CITY OF ALBUQUERQUE

Re: Sony Imageworks Grading and Drainage Plan
Engineer's Stamp dated 5-8-08 (R16/DA3006)

May 16, 2008

Re: Sony Imageworks Grading and Drainage Plan

1.0

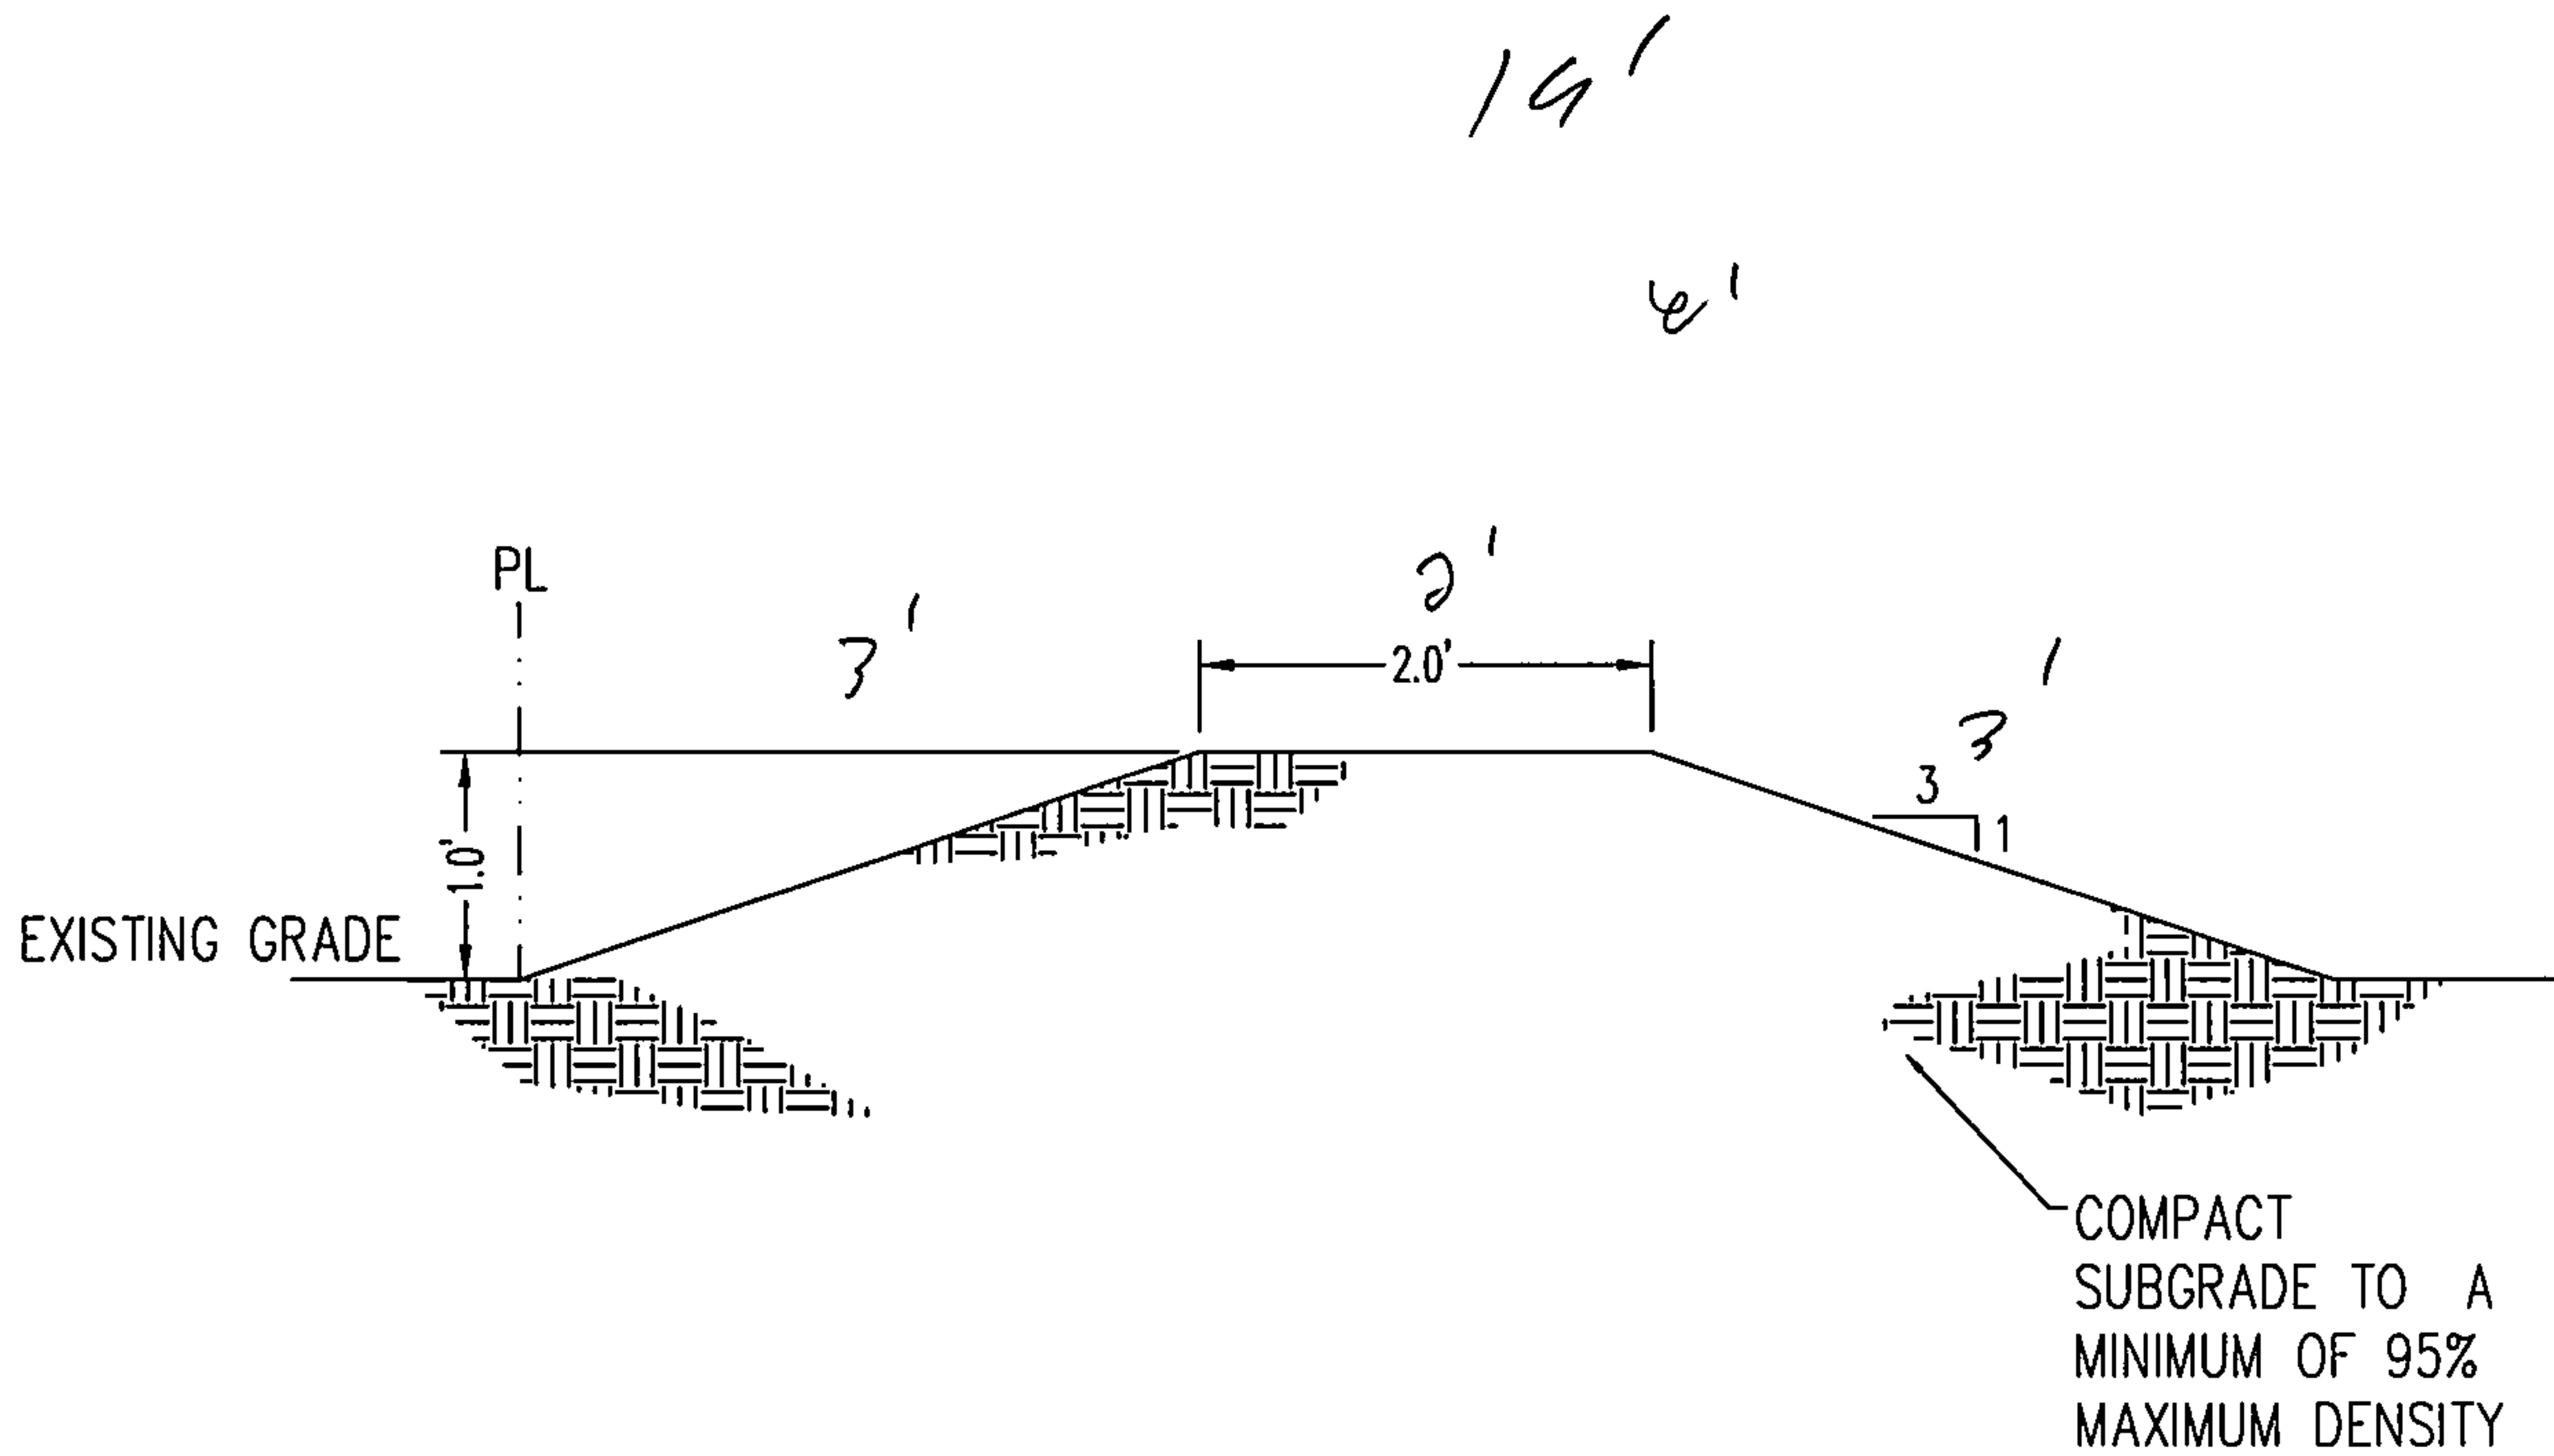
- It is not clear how the pond in Basin 3 will function. The HWL is equal to the grate height at 98.50. The volume provided is 10540 cu. ft., which is less than the 100 yr-6hr storm produces. In addition, the pipe leaving the pond will carry 2.98 cfs and the basin produces 8.5 cfs. Therefore, it appears runoff will overtop the pond and the HWL is not 98.5 as stated. Show the extents of the WSE/HWL in the parking lot if that is your intention. Also, the 24-hour storm is required for ponds of this type. Provide a hydrograph for the pond.

- It appears that runoff from the northeast portion of the future parking area will leave the site. A berm may be required along the rear property line to prevent runoff from leaving this site.

We have provided documentation with this letter that shows the inlet capacity as the pond fills. The attached AHYMO model demonstrates the 24hr rainfall hydrograph along with the HWL and peak discharge, elevation 98.75 and 2.82 cfs respectively. Therefore, the storm water does not overtop the top of pond at 99.00. Similarly, peak discharge from the basin is 8.5 cfs, but peak discharge from the pond is 2.82 cfs.

With this letter, we have provided a detail of the drainage control berm that we will issue to the contractor.
